Our ref: NO/2019/111421/01-L01
Your ref: 3/2018/1081
Date: 25 January 2019

DEMOLISH AND REBUILD MAIN FARM HOUSE. CHANGE OF USE TO ONE LIVE/WORK UNIT. CHANGE OF USE FOR A MONO PITCH BUILDING TO GARAGE UNIT FOR LIVE/WORK UNIT. DEMOLISH EXISTING FARM BUILDINGS

STARTIFANTS FARM, GOOSE LANE, CHIPPING, PRESTON, PR3 2QB

Environment Agency position – flood risk assessment (FRA)

Project Details:
 Existing site plan.

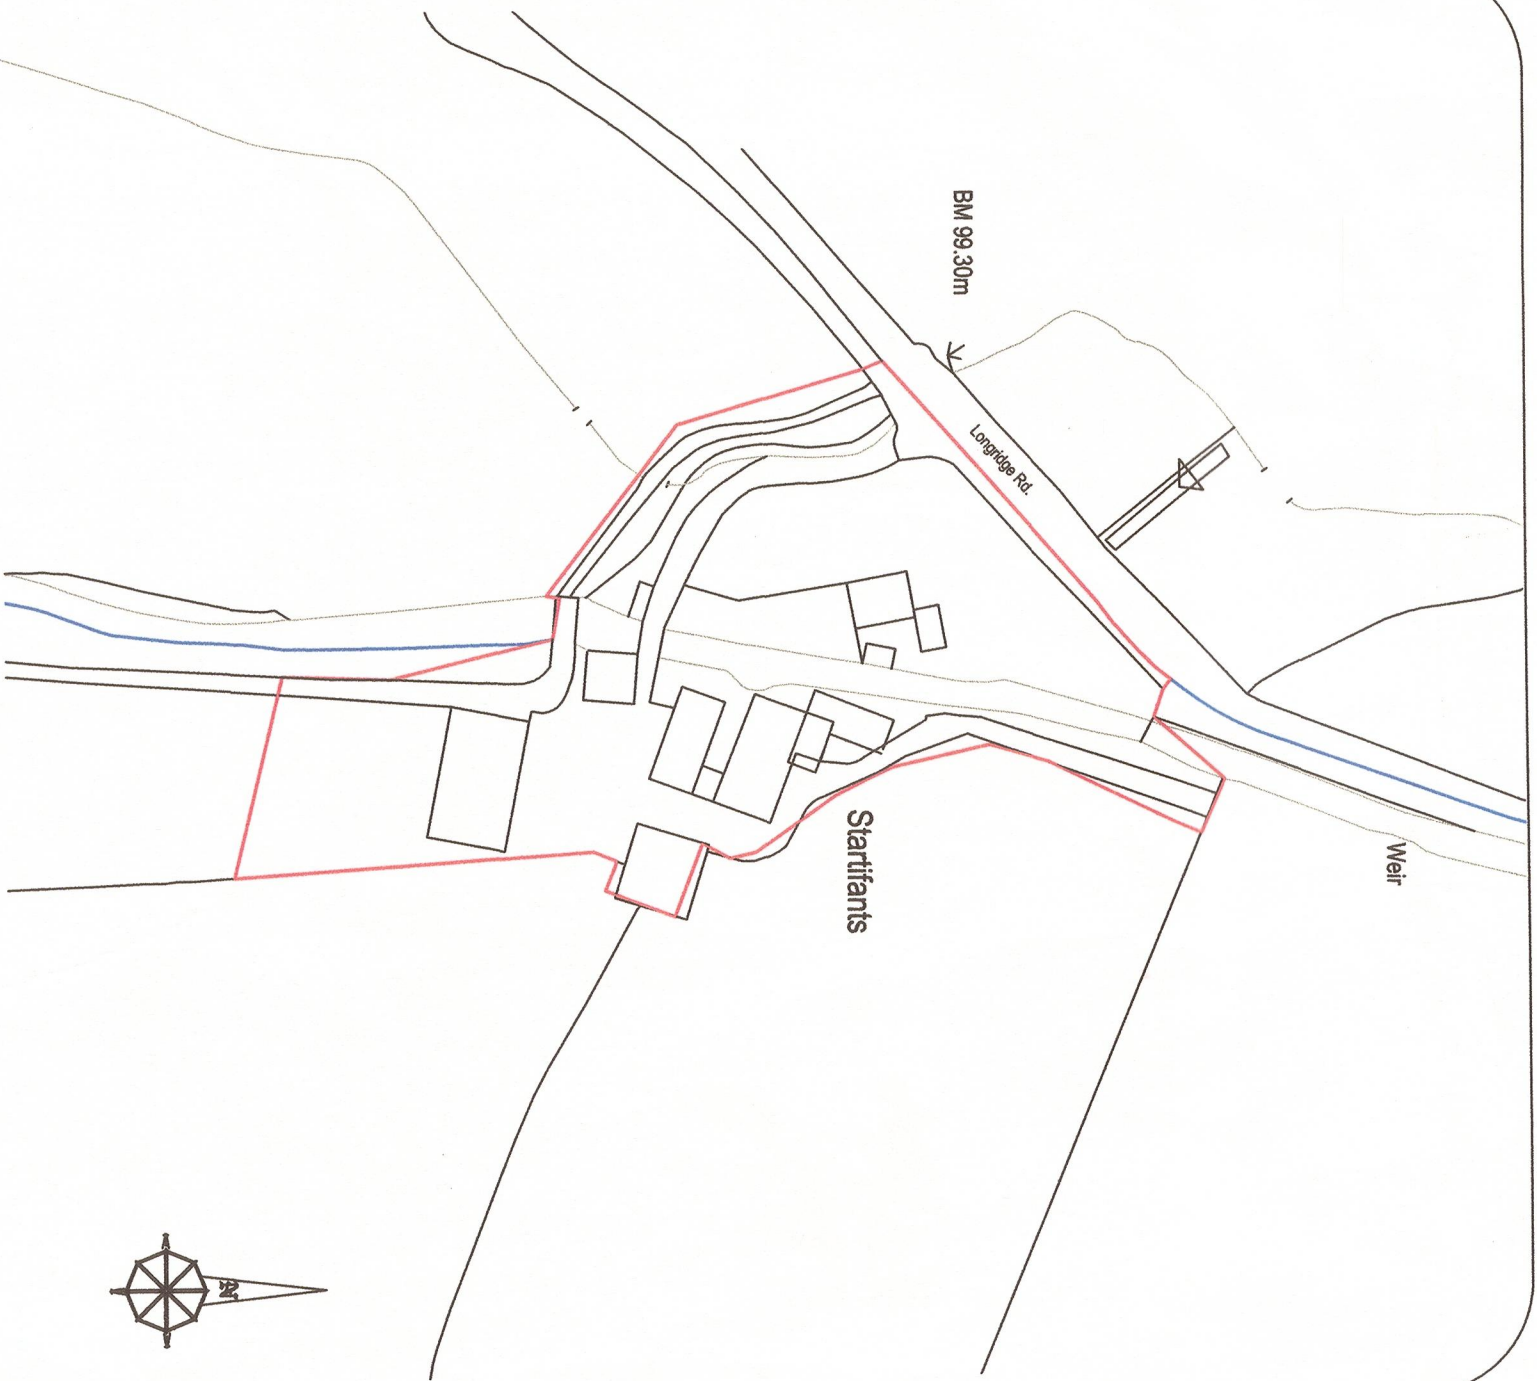
- The FRA and actual proposals differ, such as the barn conversion in the FRA is for two dwellings, but the plans are for a single live/work unit.
- Figure 3.2, Development Proposals, by J. Hadfield is different to the existing and proposed site plans submitted by J. Hadfield referenced 361A/101 and 641A/201.
- The FRA references buildings A-E in the report and on the out of date site plan (Figure 3.2), however the buildings are also referred to as F-I in section 3.3 proposed development details.

The applicant should ensure that all plans are consistent and references are clear throughout the FRA, so that a suitable assessment of risk can be made

**PROPOSED REPLACEMENT HOUSE
(Building No. 1)**

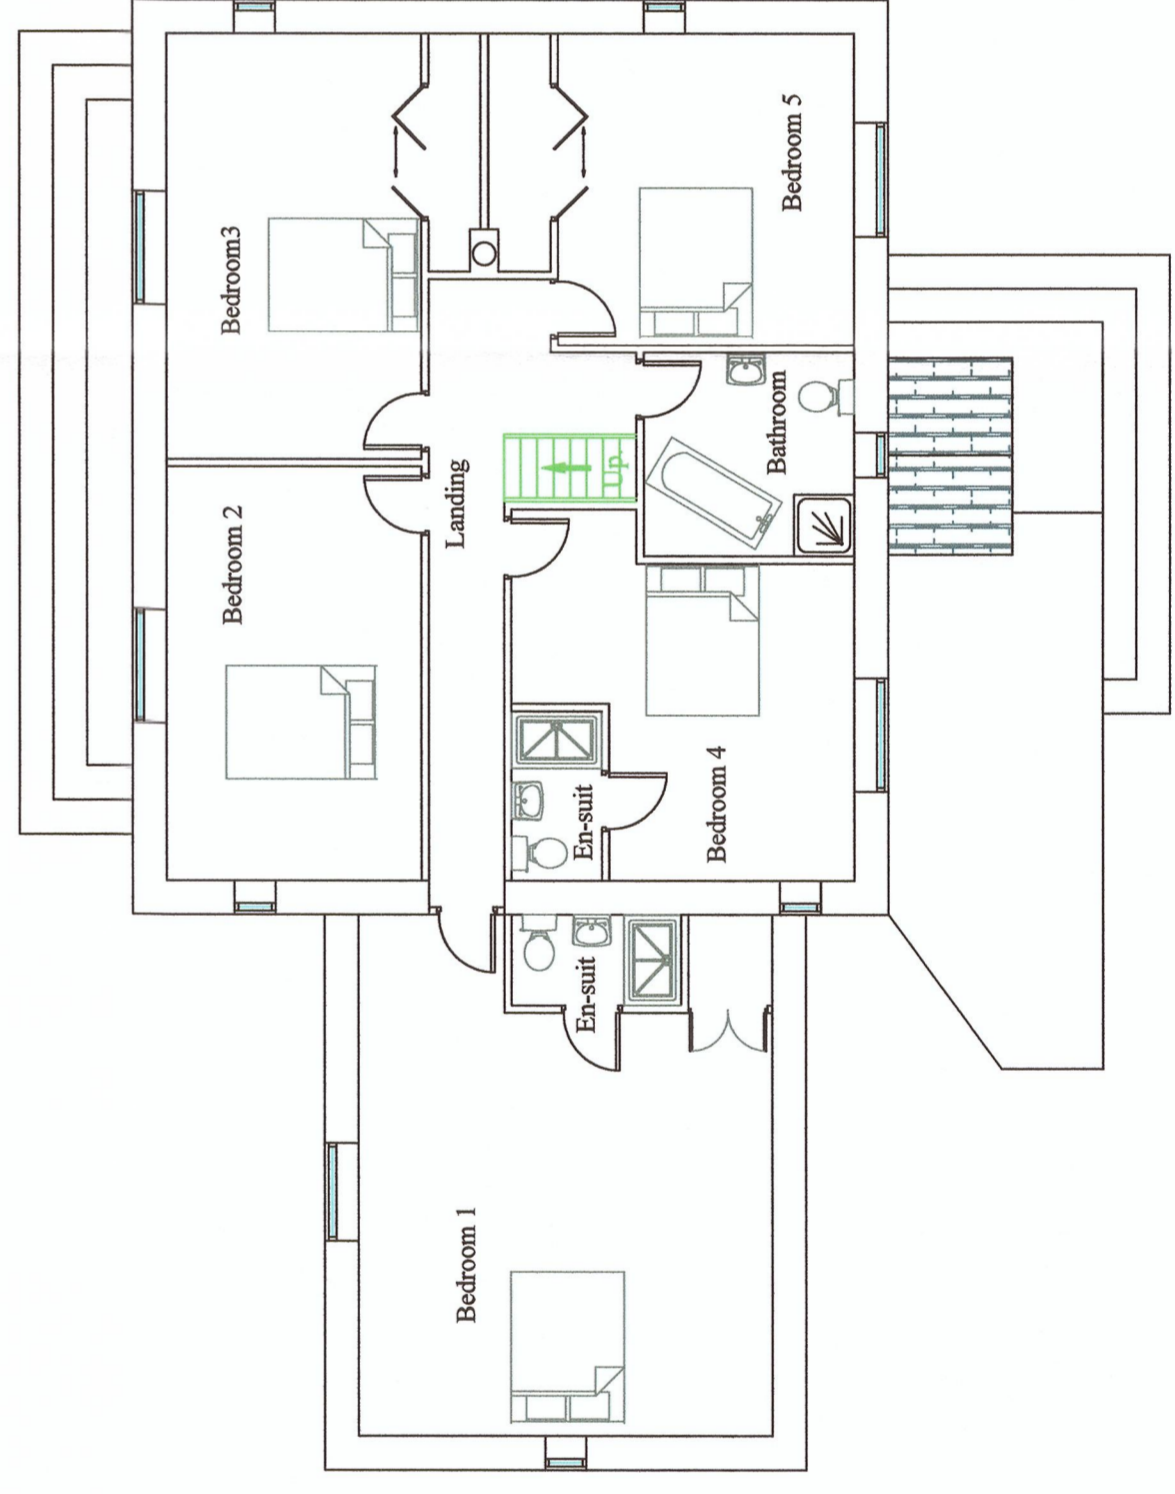
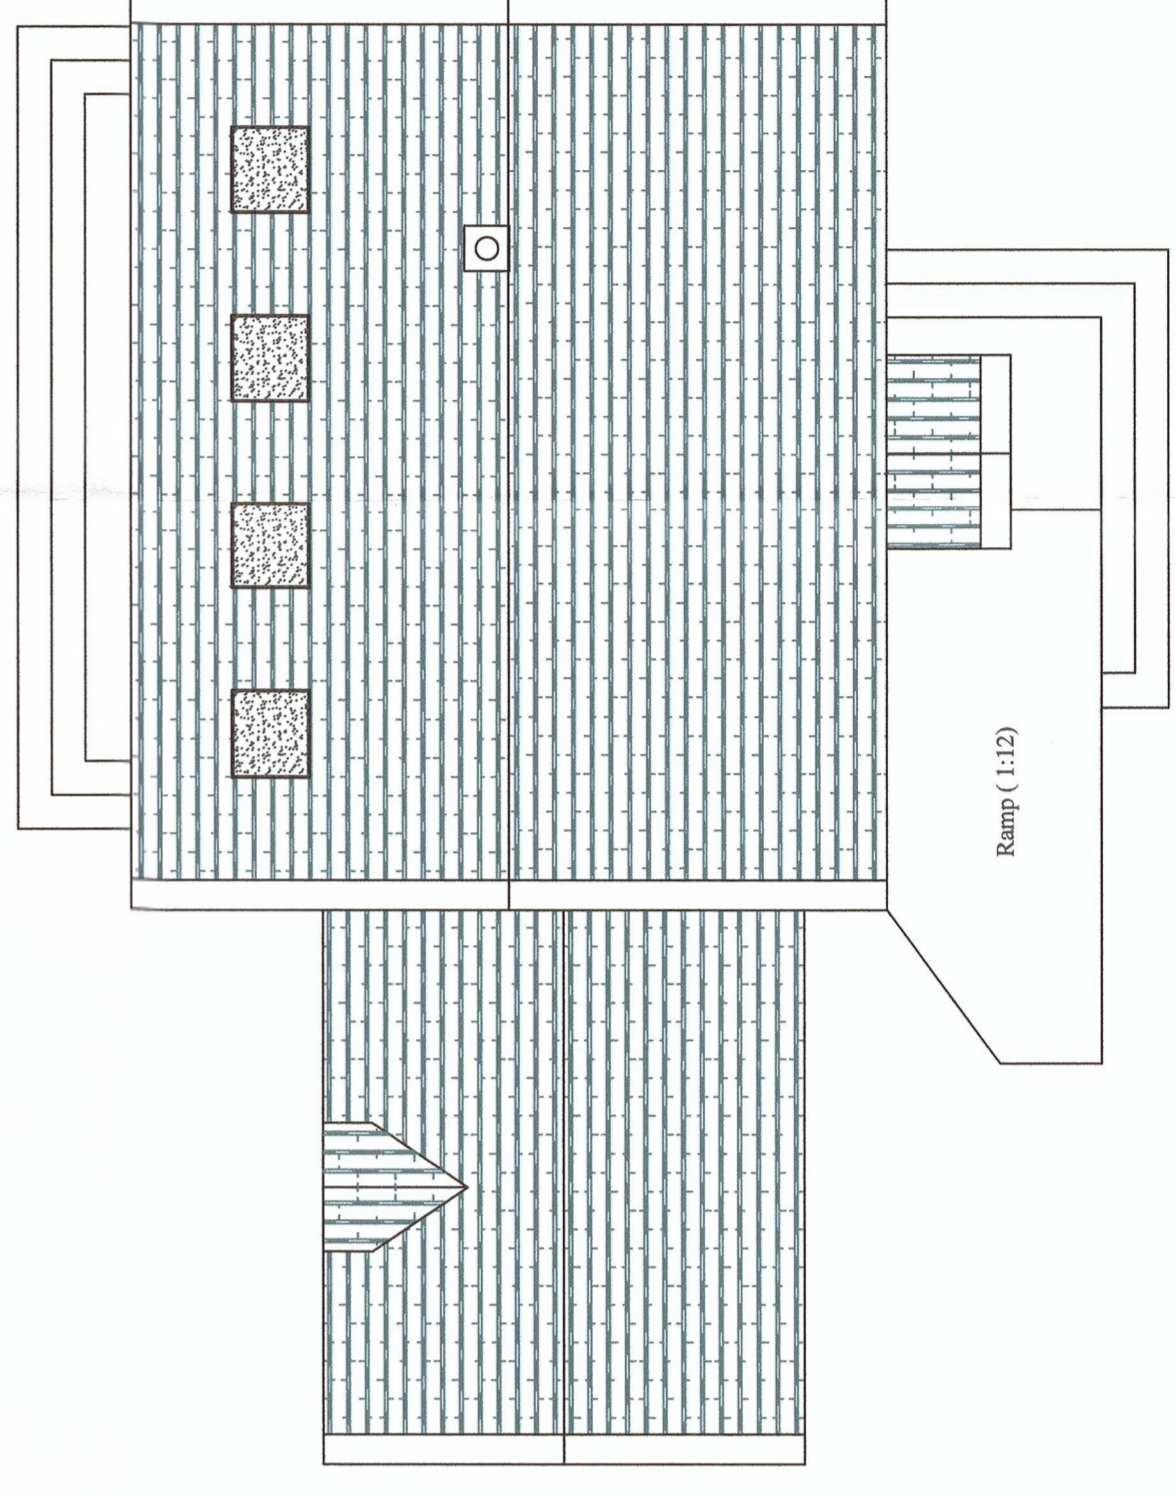
To accommodate the finished floor levels, section 7.1 of the FRA states that non-habitable space will be provided at ground floor level however 'Proposed replacement house plans and elevations, J. Hadfield Engineering, 361A/202, July 2018' demonstrates a habitable ground floor with sitting, dining and a kitchen. This does not accord with the recommendations within the FRA. In order to comply with the required finished floor levels, the ground floor of all dwellings must be non-habitable.

The finished floor level of the replacement dwelling should be set 600mm above the 1 in 100 year flood including 35% climate change allowance.
